CITY OF PORTLAND, MAINE
ZONING BOARD OF APPEALS

R-5 – Residential Zone
Conditional Use Appeal

DECISION

Location of subject property : 240 Brighton Avenue
CBL 186A F009001
186A F022001

**Basement Plan**  
240 BRIGHTON AVE

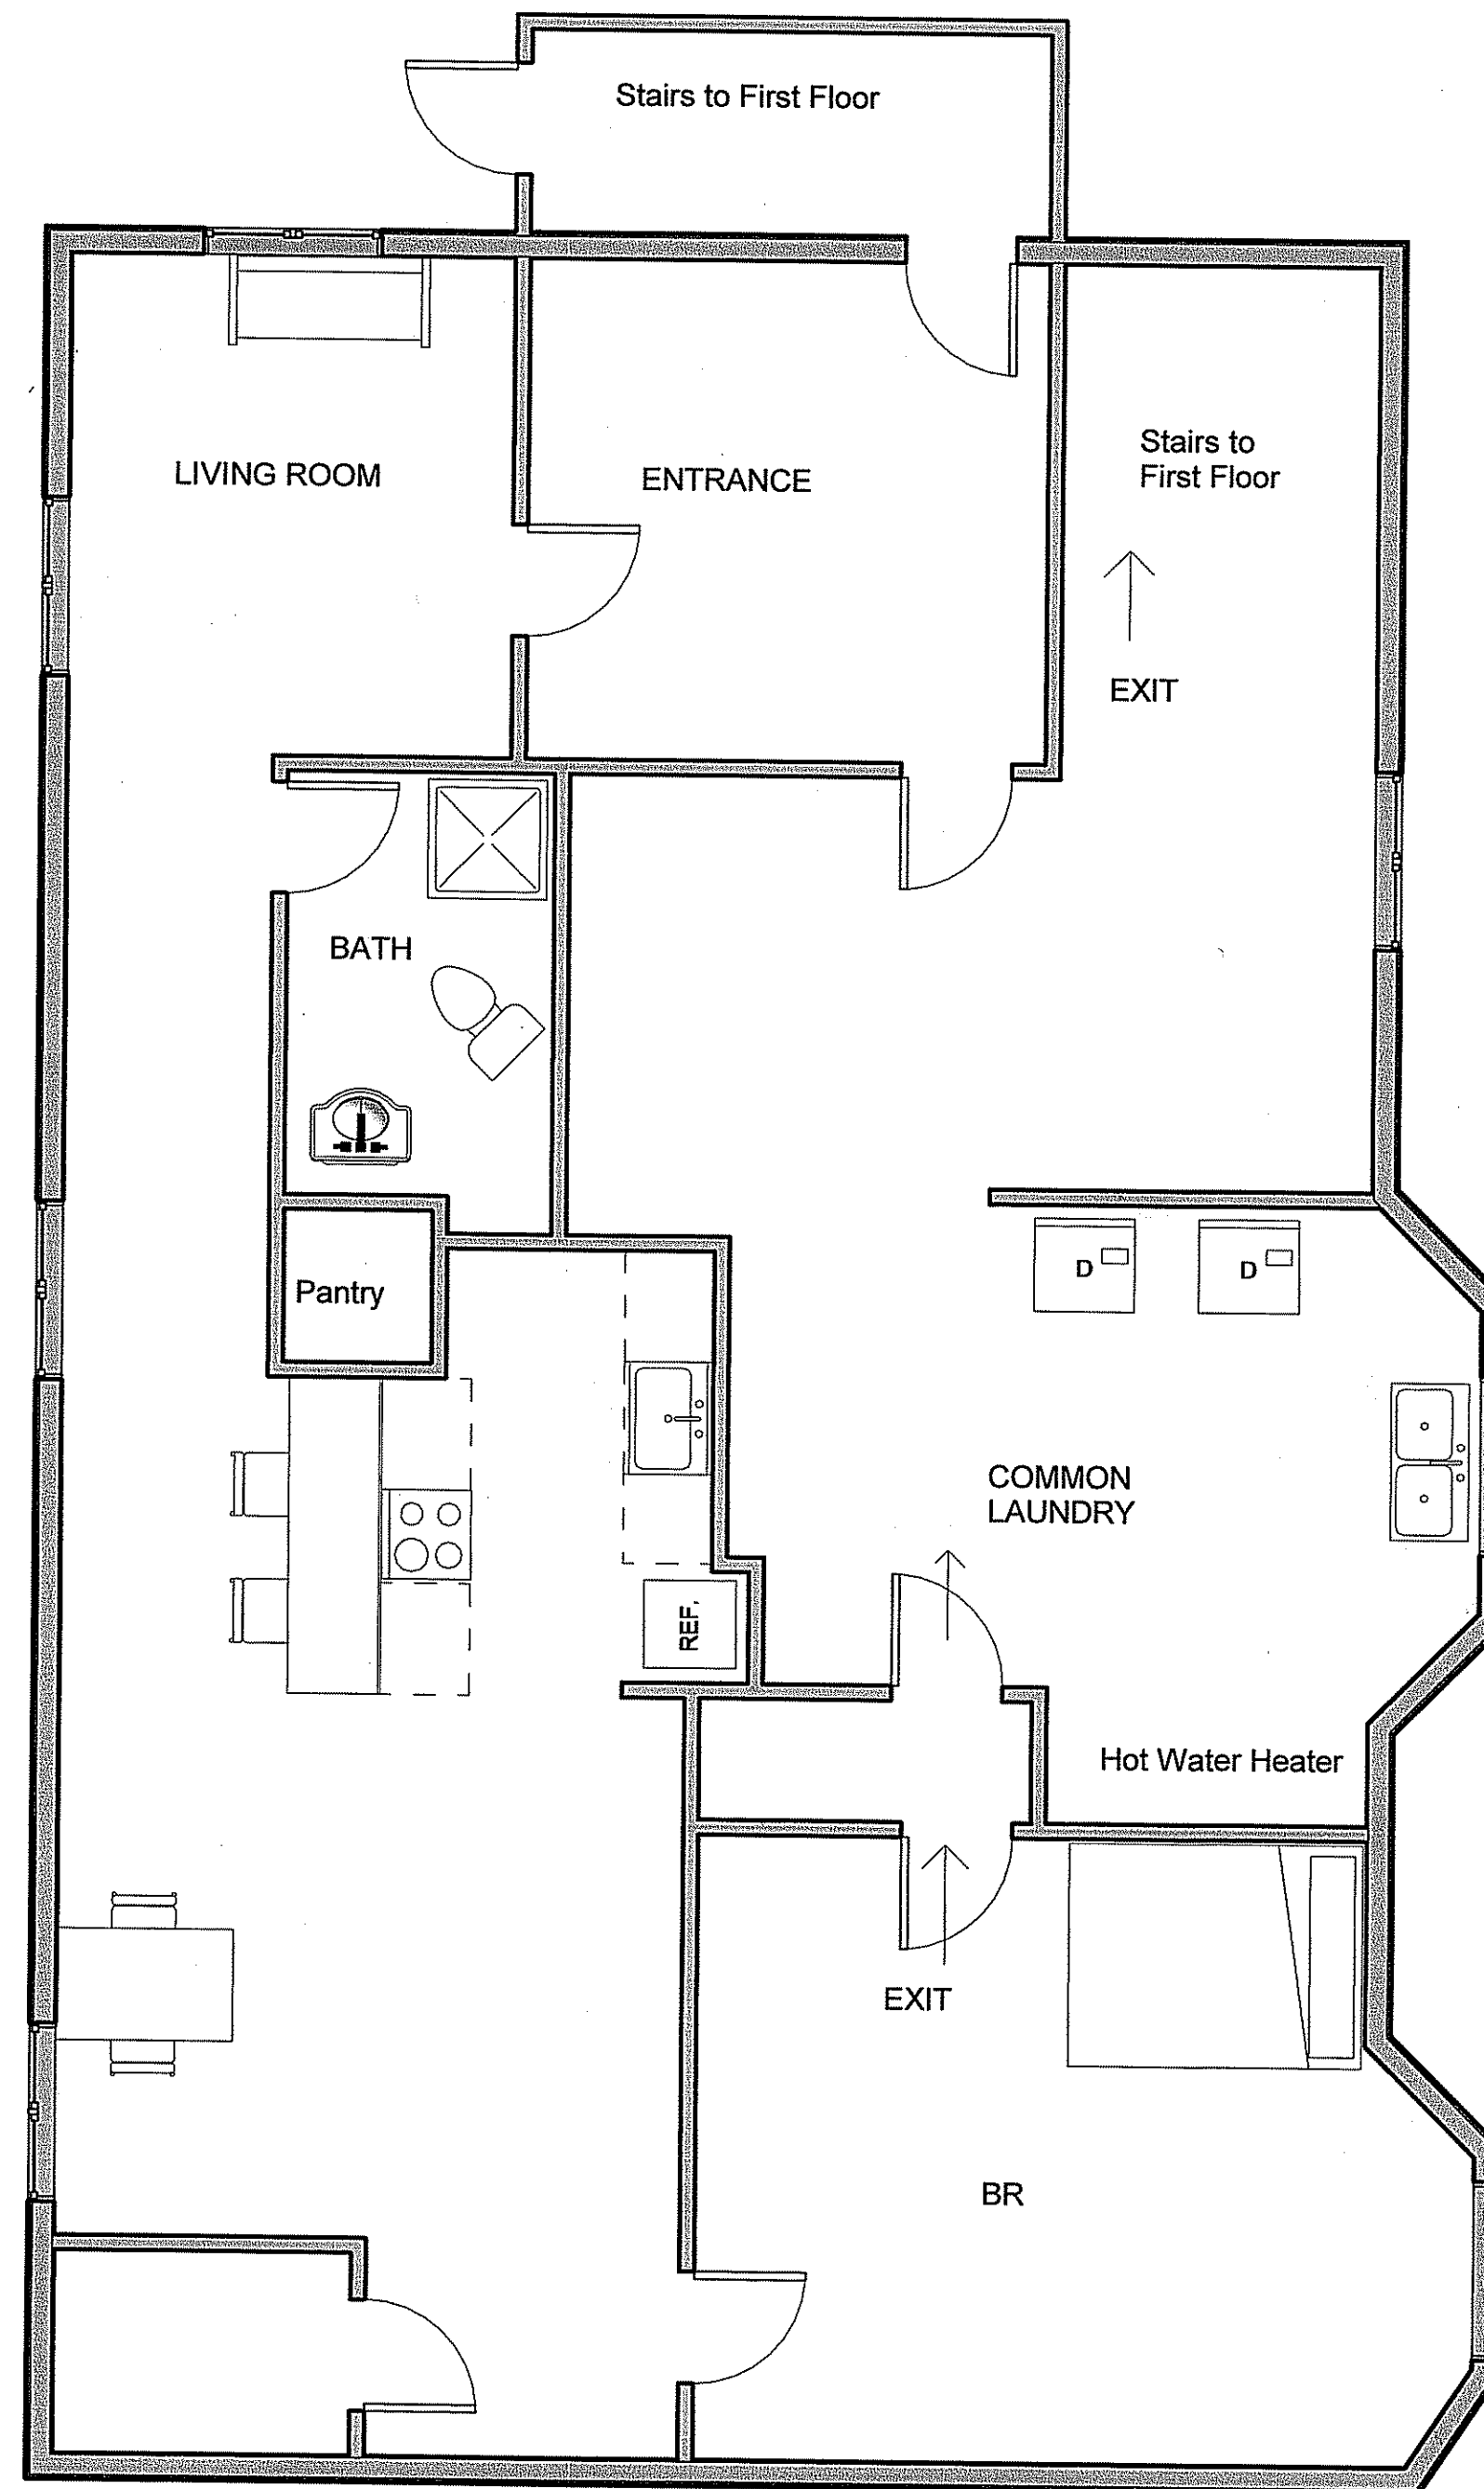
Satisfied *for attic unit* Not Satisfied *Basement unit*

*Attic unit > 400 sq feet. unit remove more 10%
entire gross floor area of basement unit is < 2/3 floor to ceiling height above average ground. no floor area above grade.*

AS to Basement unit:

Option 3: The Board finds that all of the standards described above have not been satisfied, and therefore DENIES the application.
